Our Ref: K/22/09/

Construction of third floor extension with flat roof, first floor balcony access to sun deck, garage extension, additional driveway parking & boundary wall erected to front of property

Chelsfield 53 Coastal Road East Preston

Kingston Parish Council has the following objections and comments on the development proposed in planning application K/22/09: ☐

Proposed Boundary Wall - including proposed front elevation
1:50

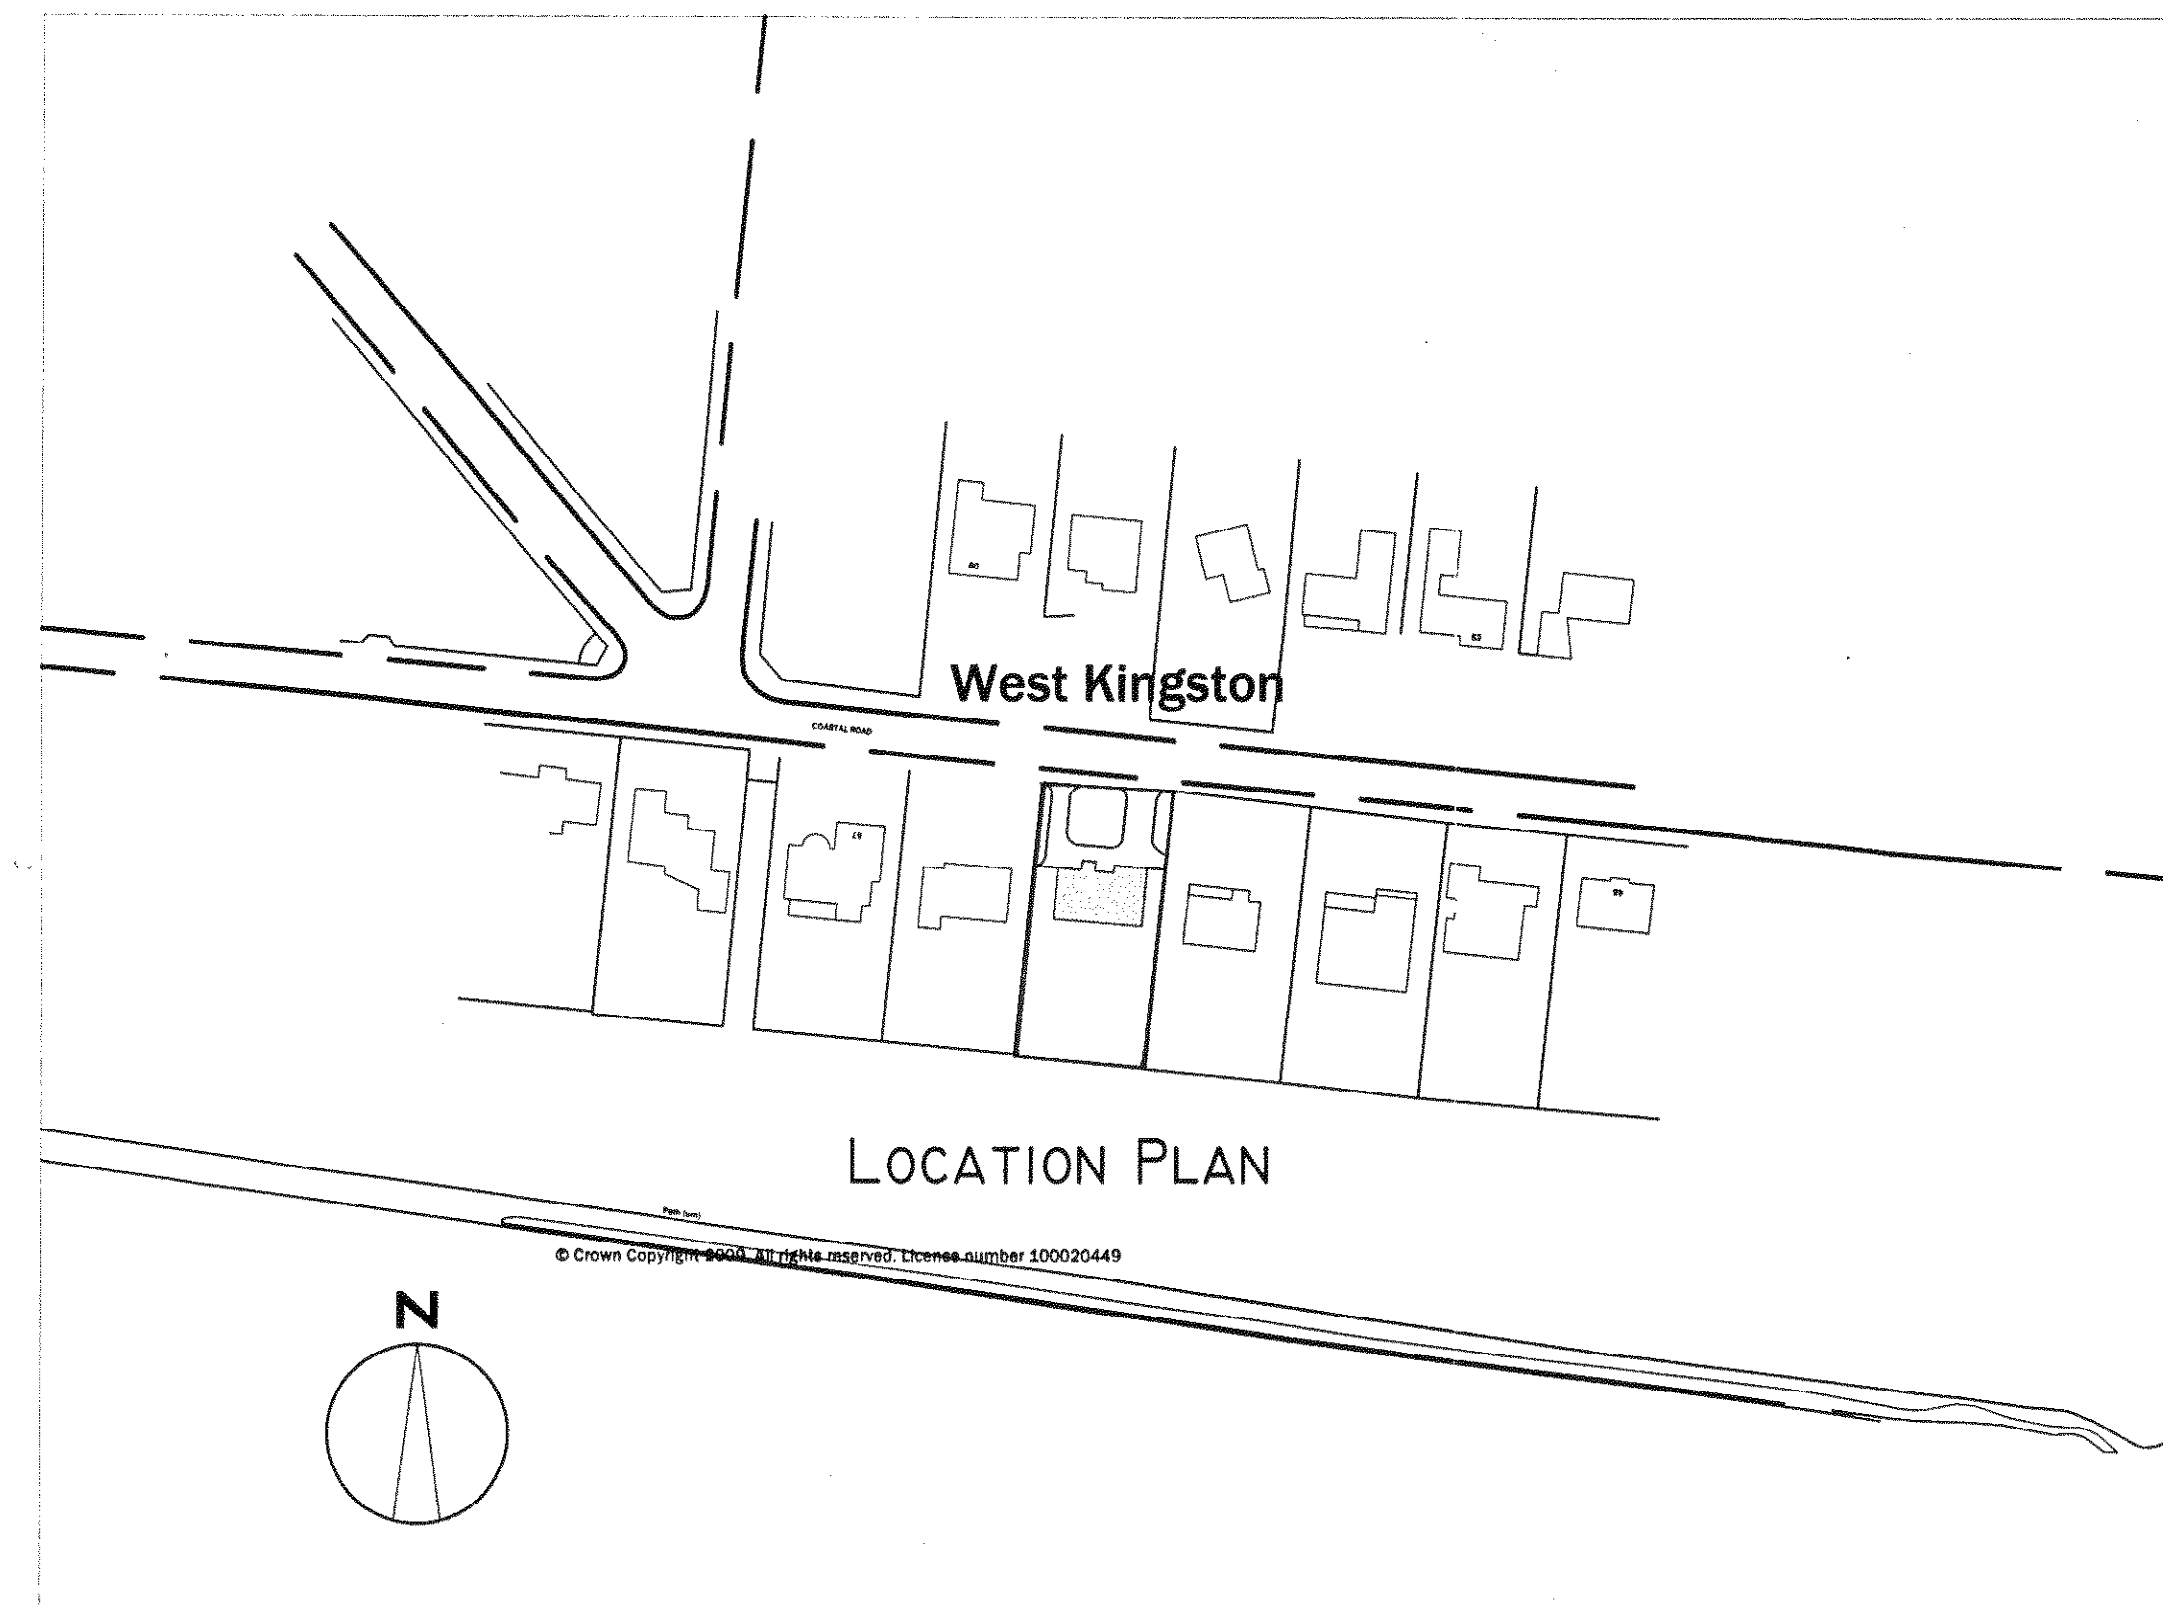
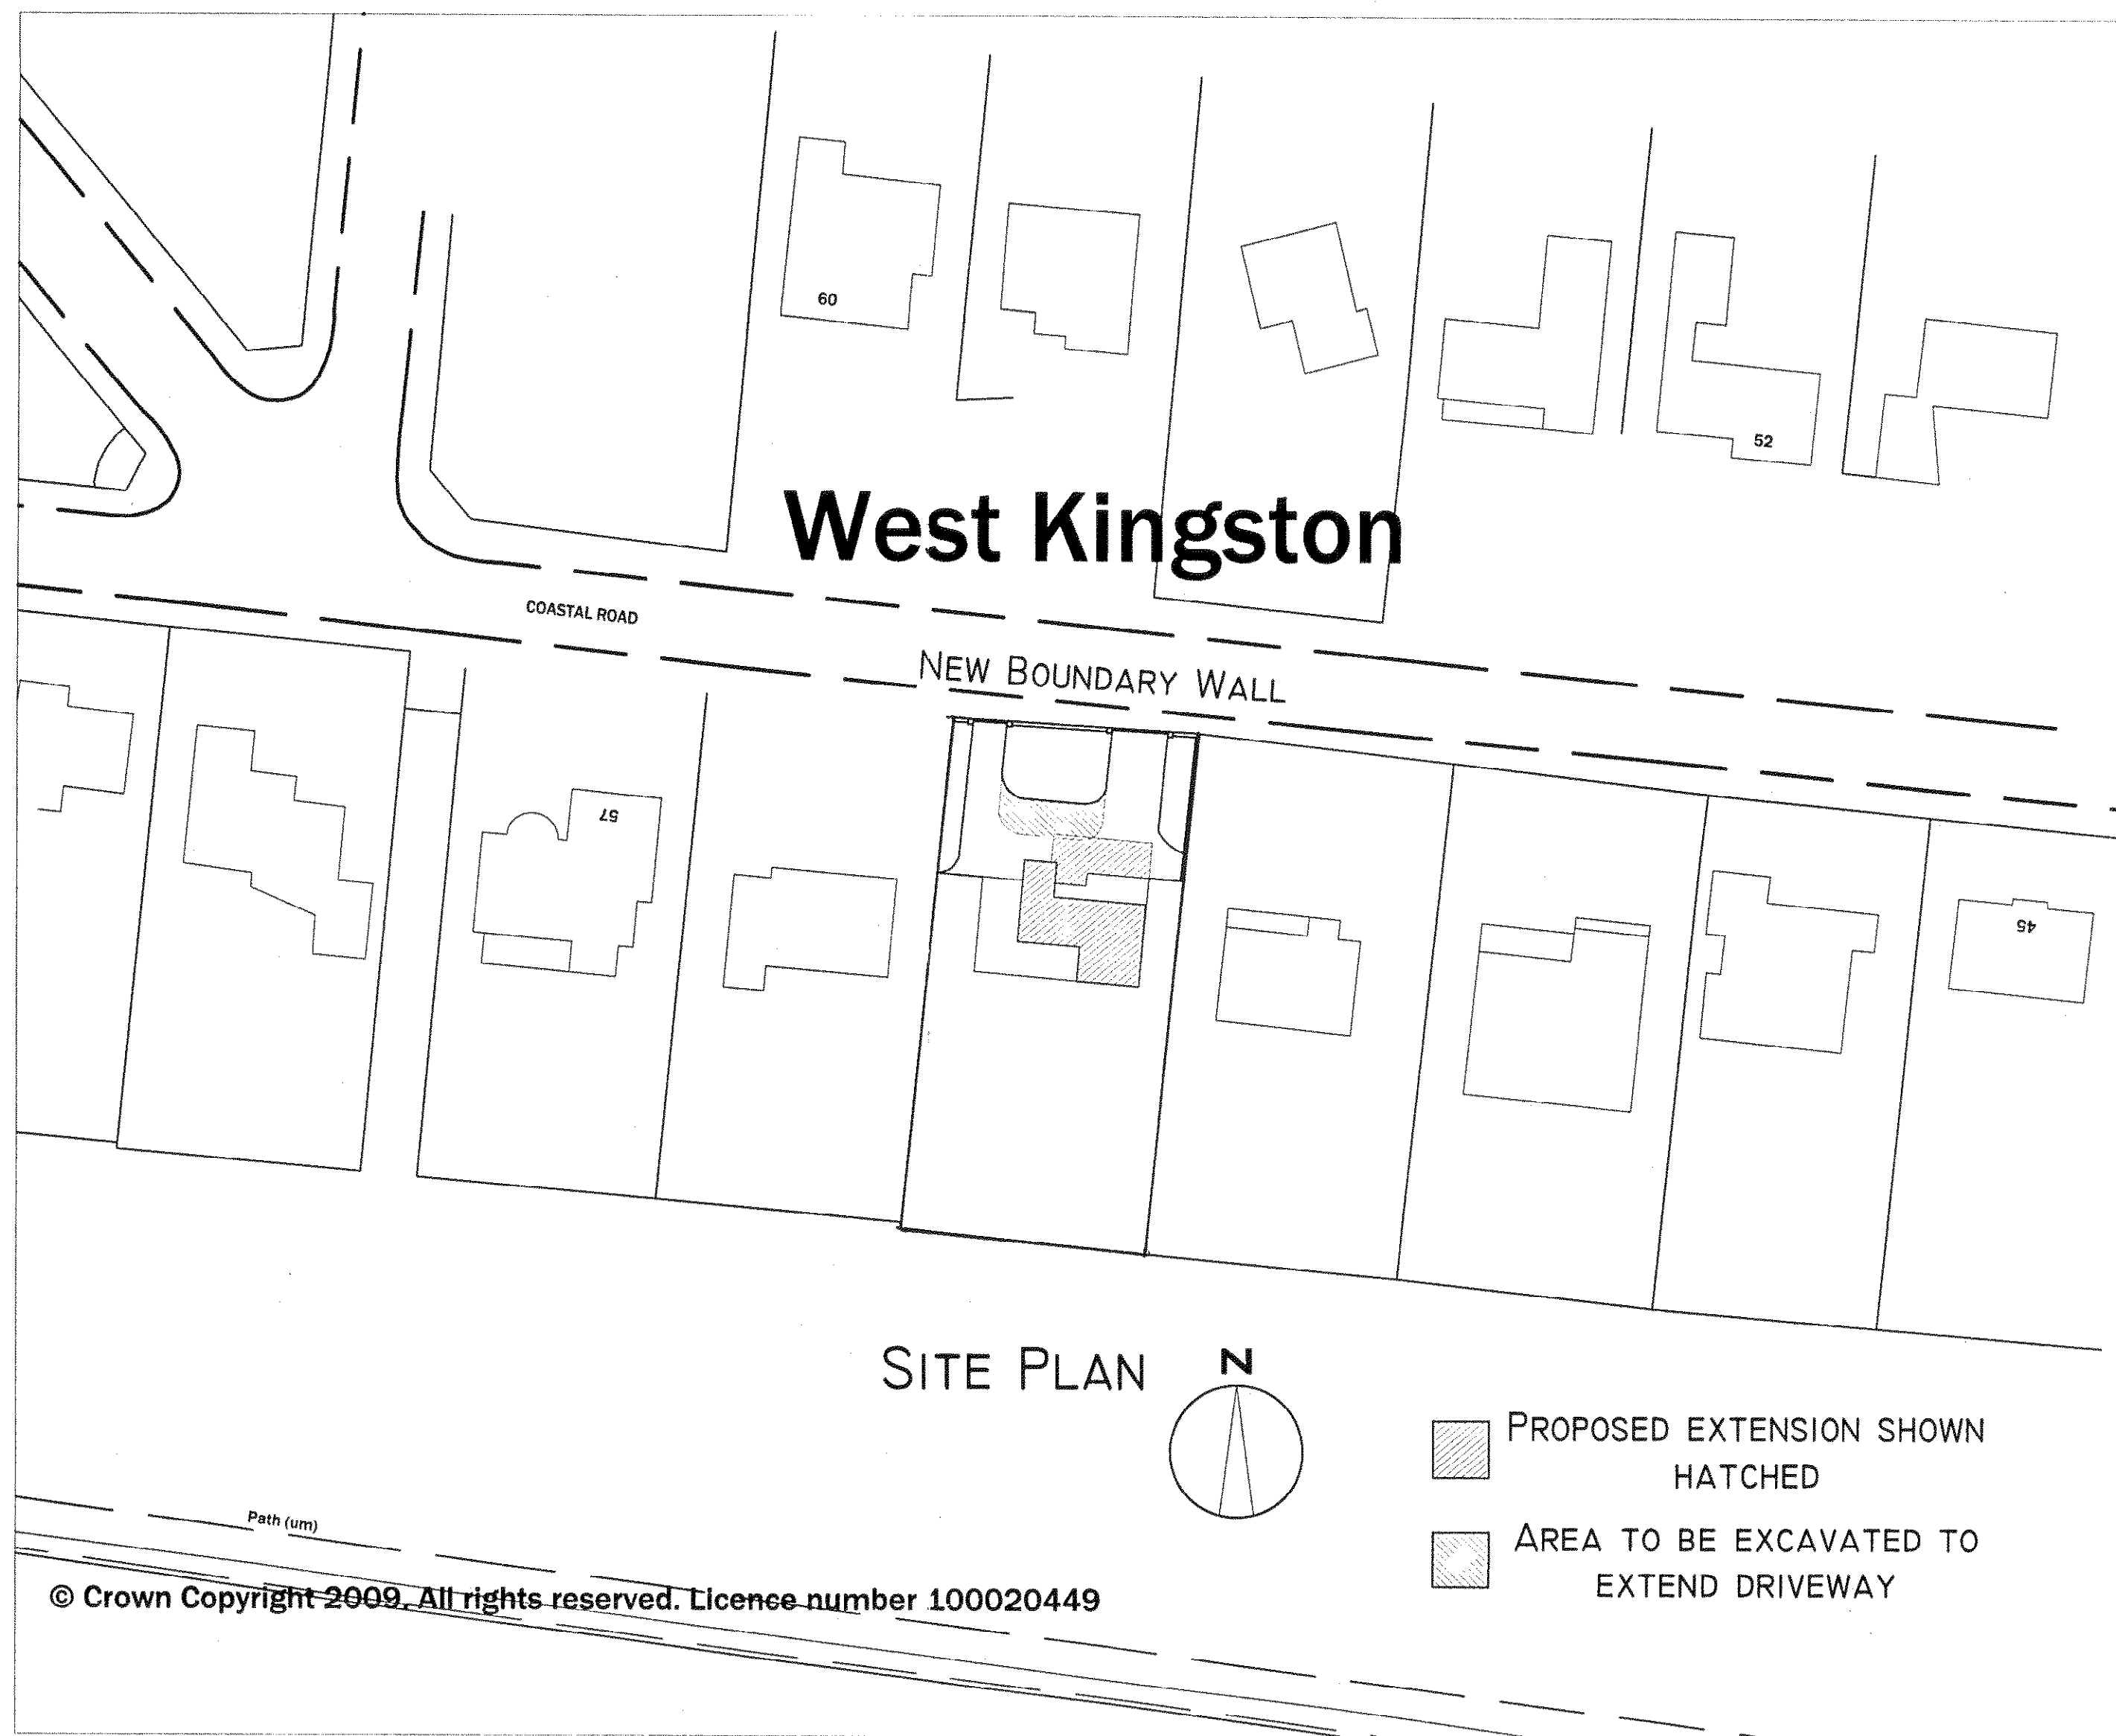
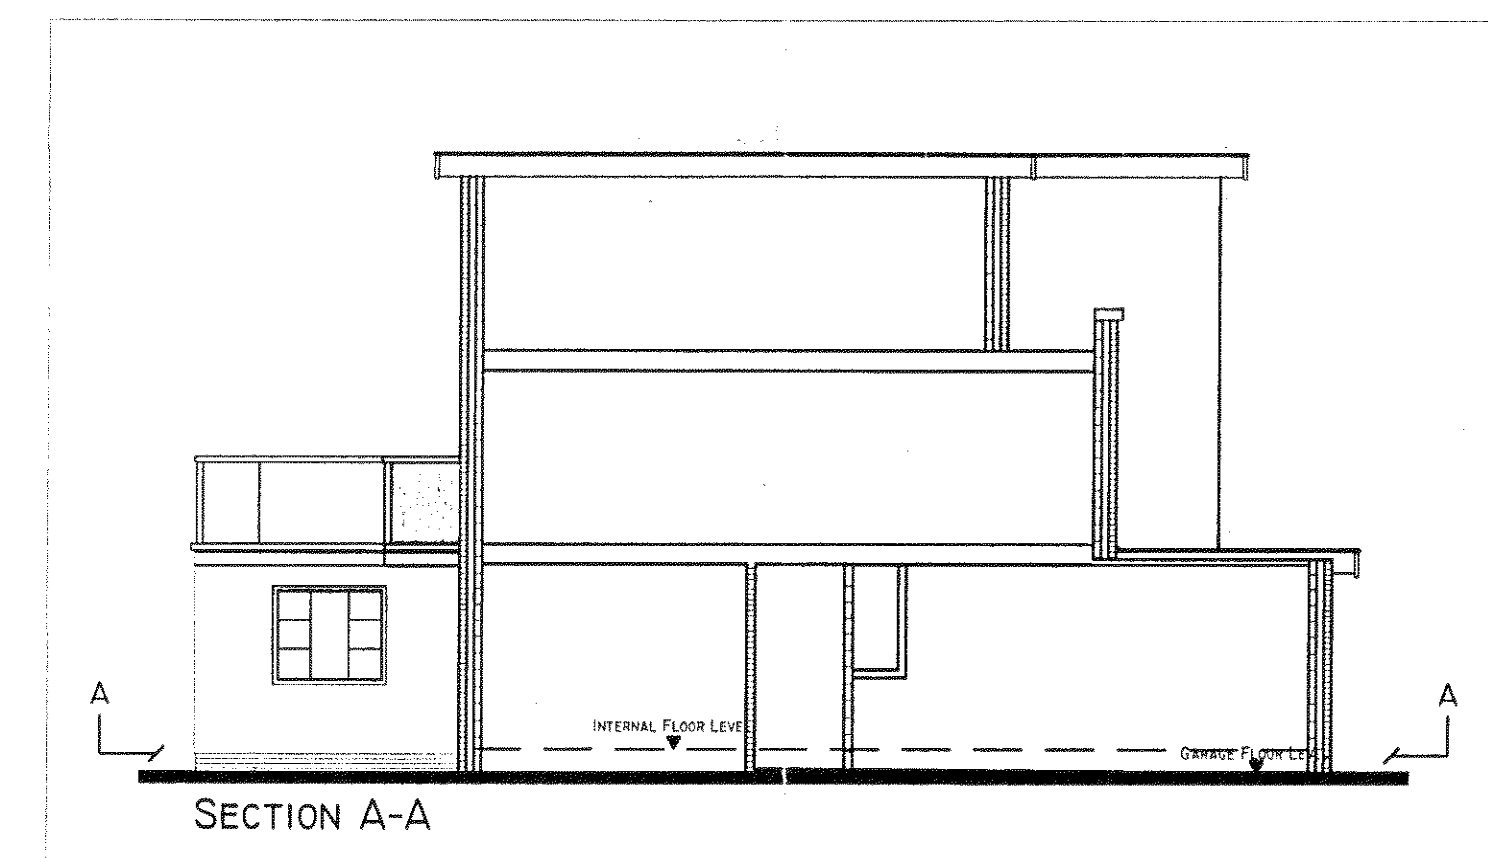
3. The erection of a high boundary wall to the front of property will have a detrimental effect on the street scene being a complete reversal to the existing open aspect of the frontage. ☐

4. Additionally re the proposed front boundary wall, there is a concern that this will create a hazard for pedestrians and motorists as there is insufficient visibility splay and sight line when vehicles are exiting the property. ☐
